Your Ref :
Our Ref : M/60/15/NMA

Application for a non-material amendment following a grant of planning permission M/51/07 relating to change the 2 storey front extension to single storey front extension with flat roof, external length of extension to be 3.2m instead of 2.9m & addition of obscured small window within shower room.

18 Sea Way, Elmer Sands, Middleton On Sea,

GROUND FLOOR PLAN

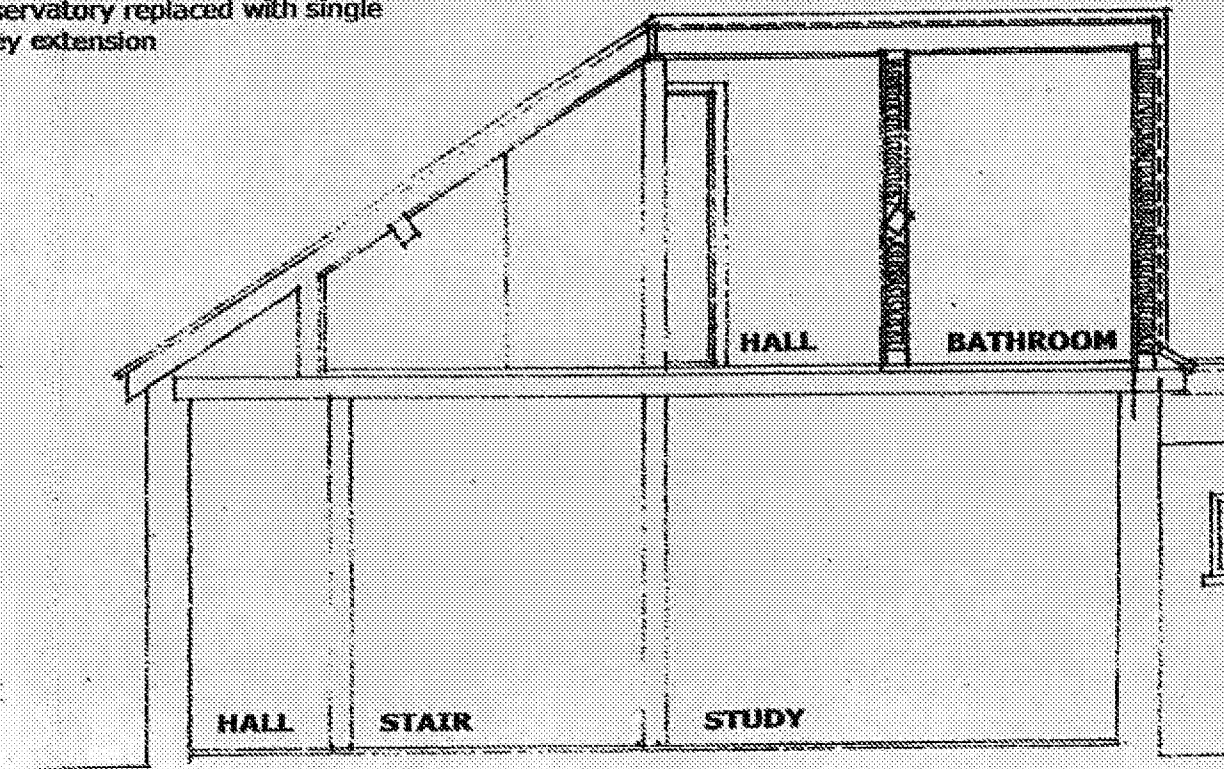
I refer to your recent application for a Non Material Minor Amendment. From the information submitted it is evident that the proposed revisions would result in the erection of a single storey front extension which would be materially different from the extension previously permitted under M/51/01, including:

1. Being 3.2m in depth rather than the previously permitted 2.9m in depth.
2. Having a flat roof and being single storey rather than having a pitched roof as a continuation of the existing dwelling and including room in roof space.

Planning permission is therefore required for the amendment(s) proposed in this application.

DRAWING TITLE
ELEVATIONS

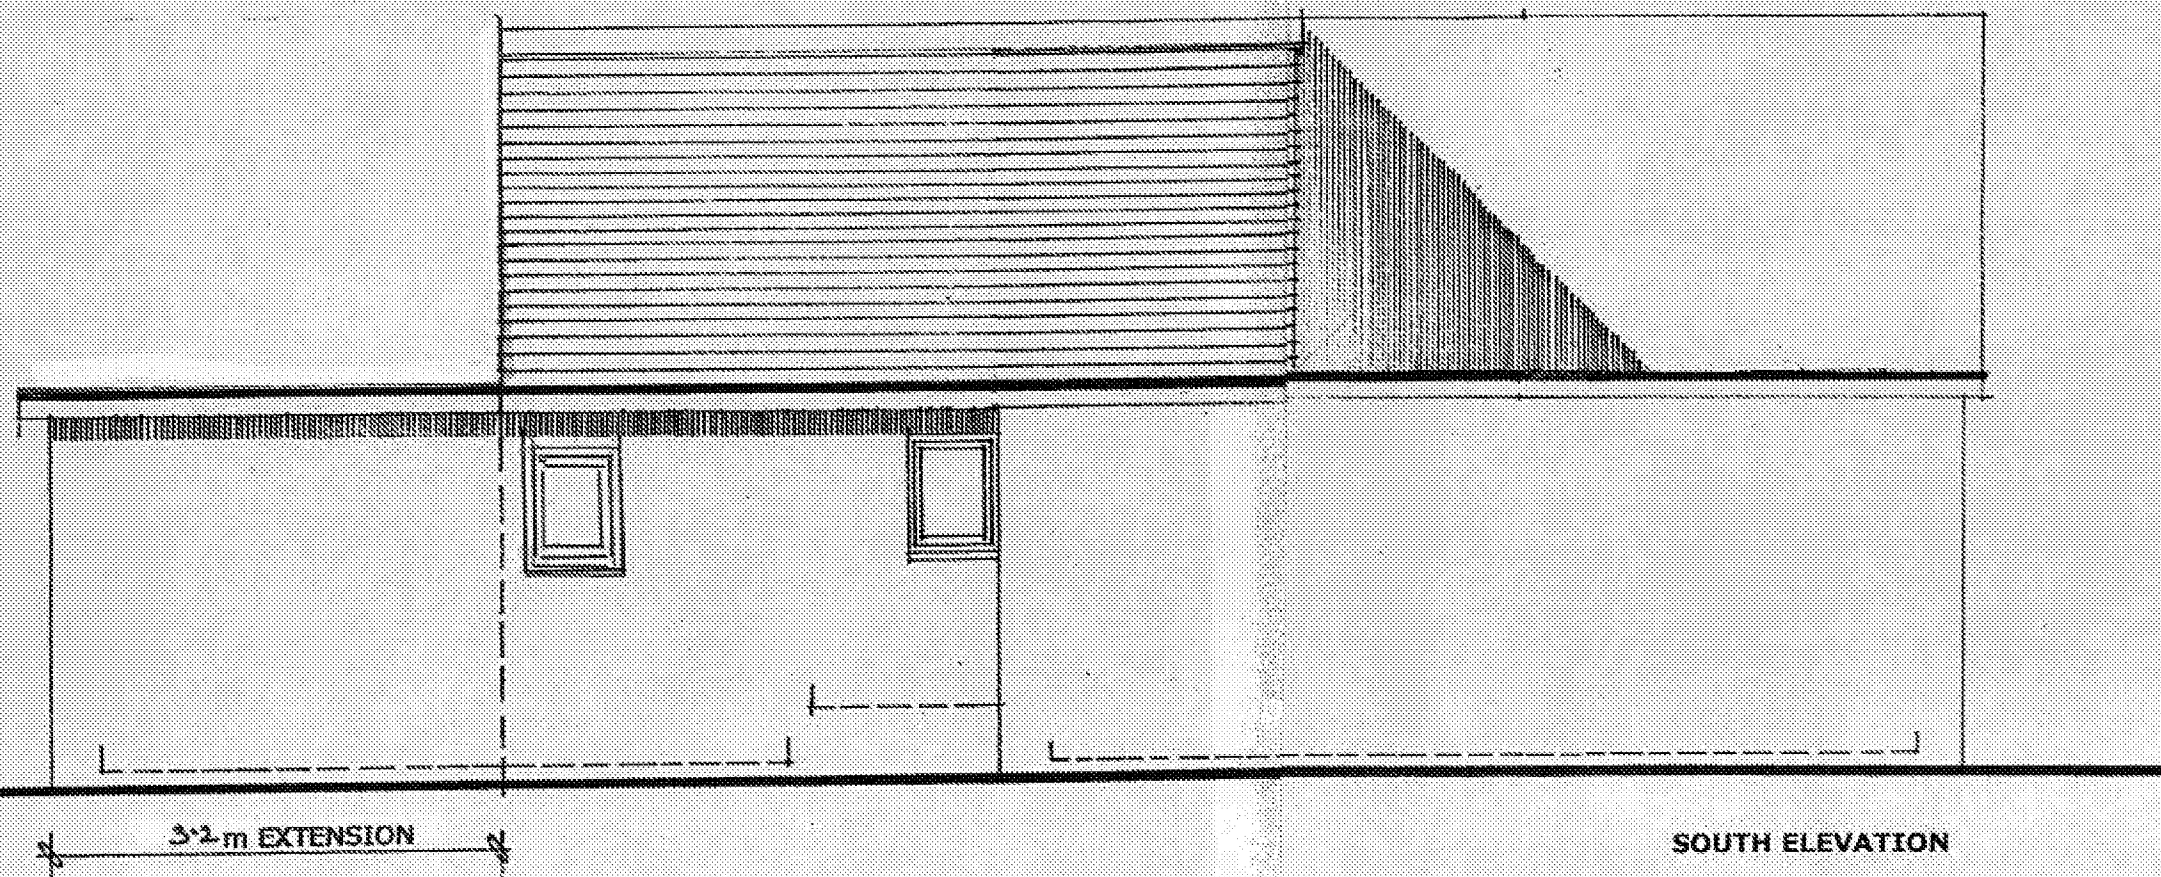
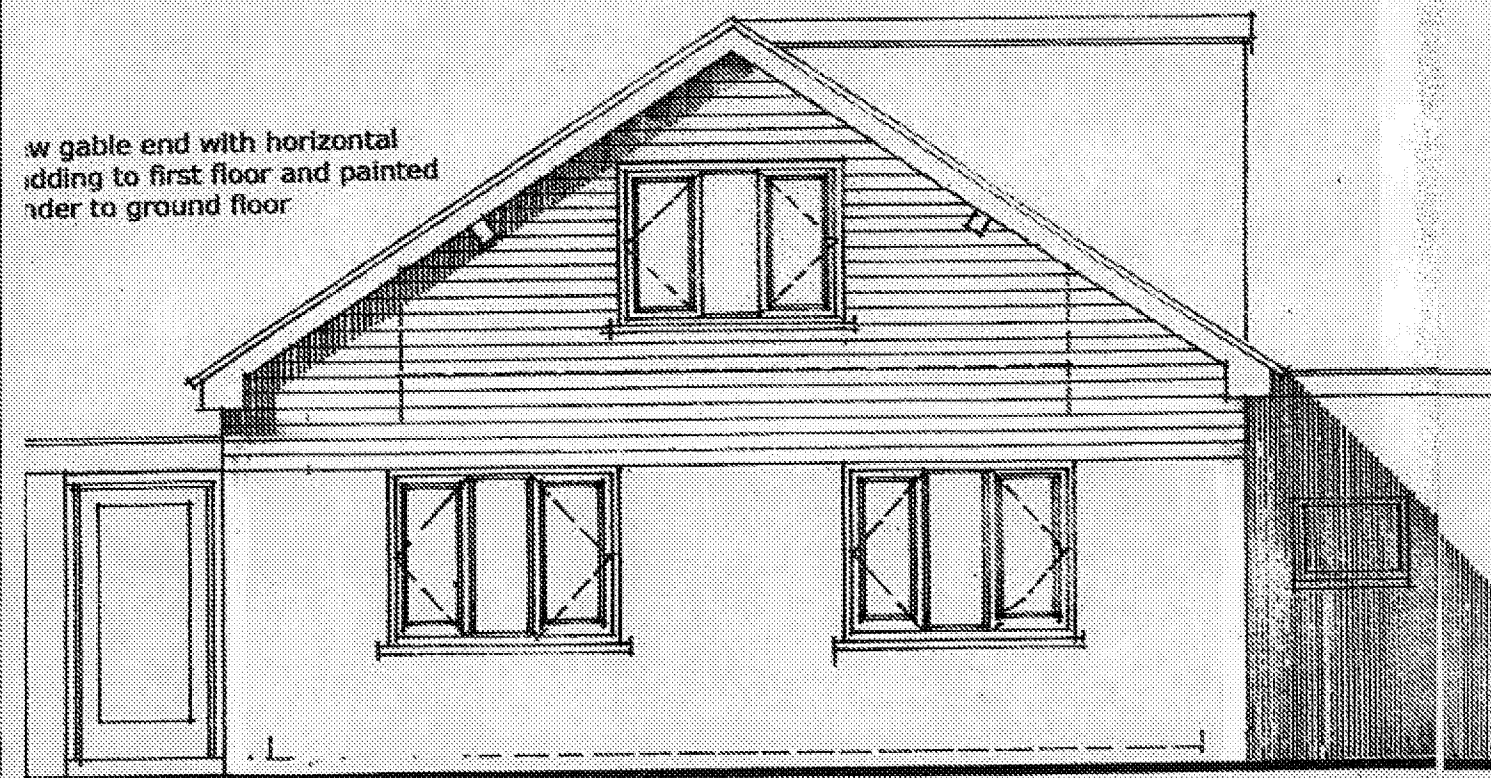
(It should also be noted that the revised proposal shown in this application, a single storey front extension with flat roof, is considered to be unlikely to be acceptable to the Council in terms of its visual appearance and potential detriment to the street scene. The applicant will wish to consider a revised proposal which is more sympathetic to the appearance of the existing dwelling and therefore more likely to be acceptable in terms of the street scene).
